From: Bryan Butcher <[REDACTED]>
Sent: 27 June 2019 09:45
To: Amber Willard
Subject: Re: aw/117/19/hh

1st floor plan

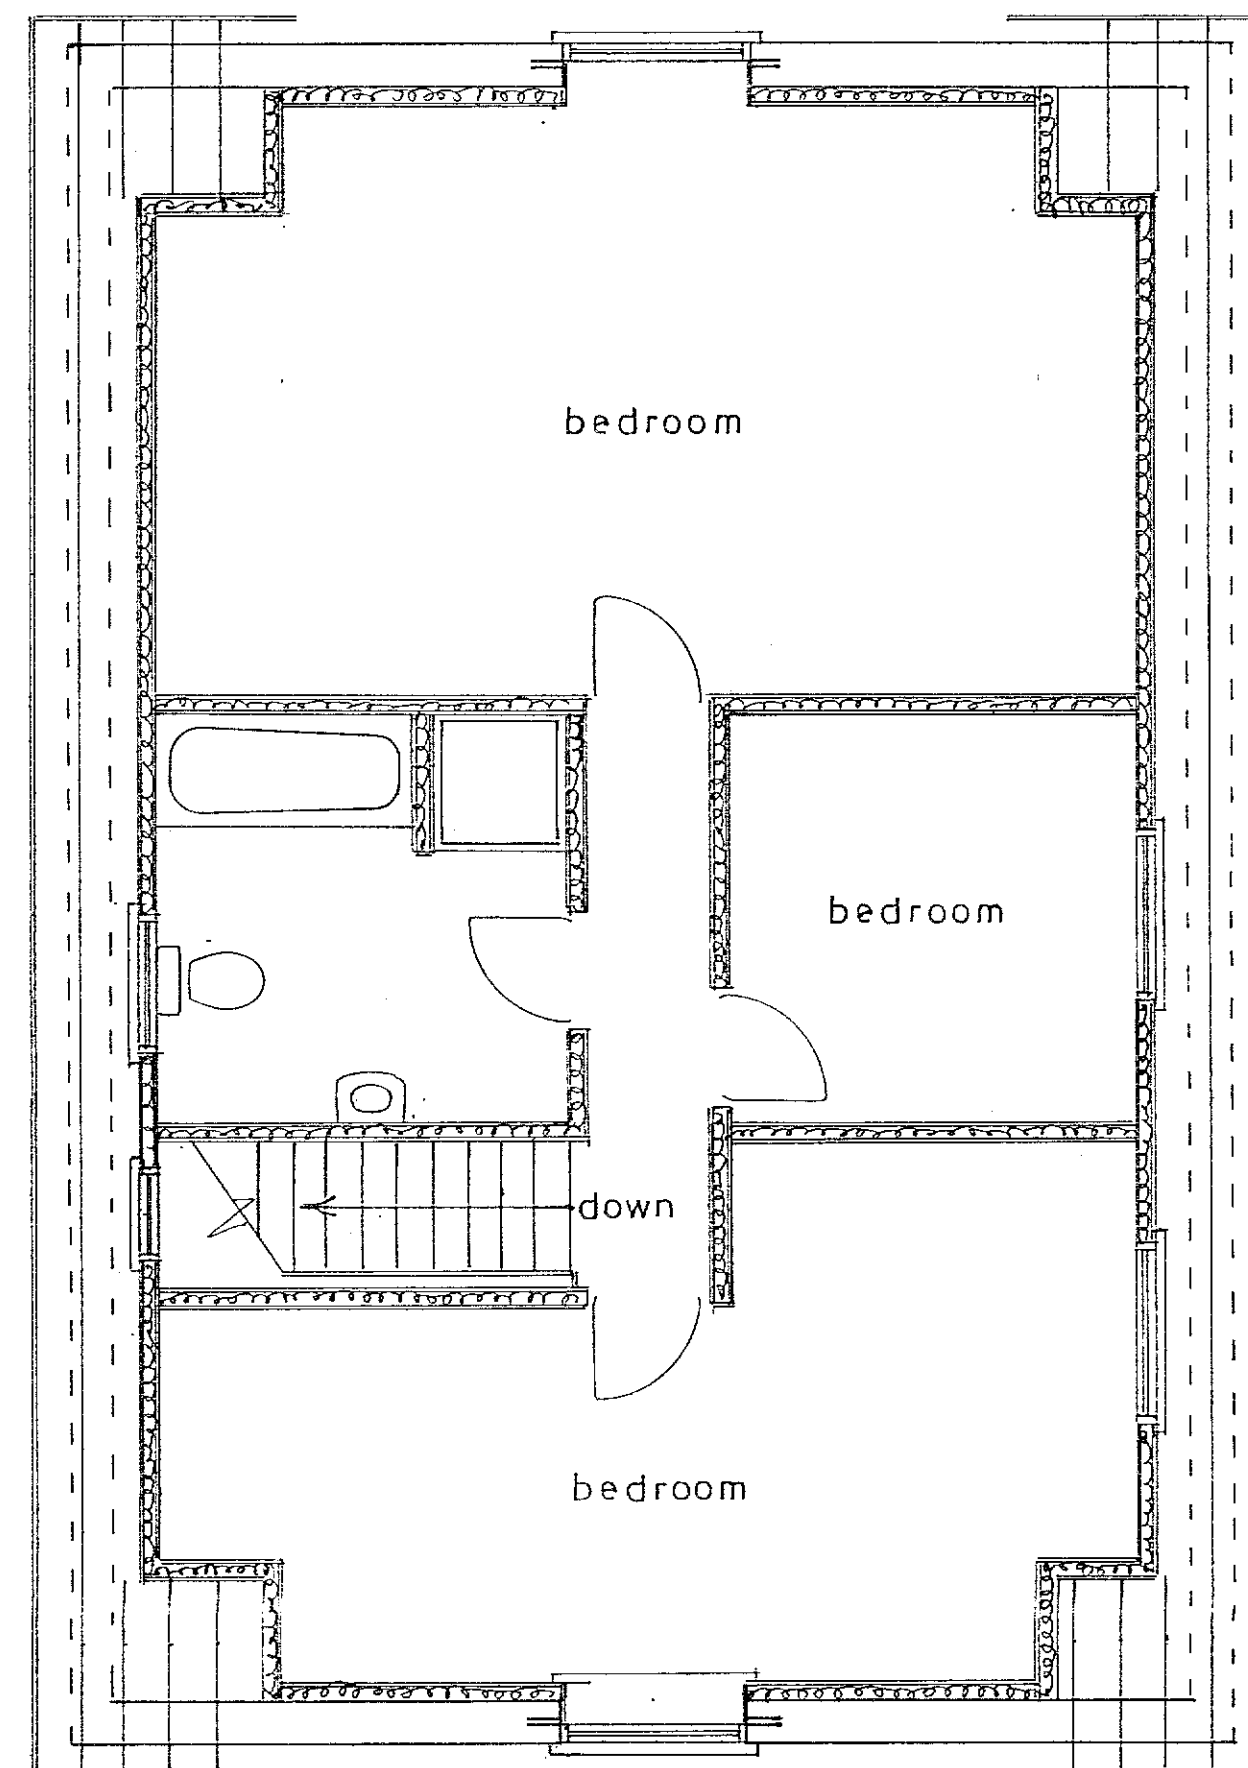
Thank you , I can place a condition stating it to be obscured glazed.

I have no problem with including obscured glazing to the front bedroom west facing window as I can provide a necessary Building Regulations 'Means of Escape' casement opening to the front window frame.

Would you prefer that I mark it on the plans or will you just place a Condition on the approval document.
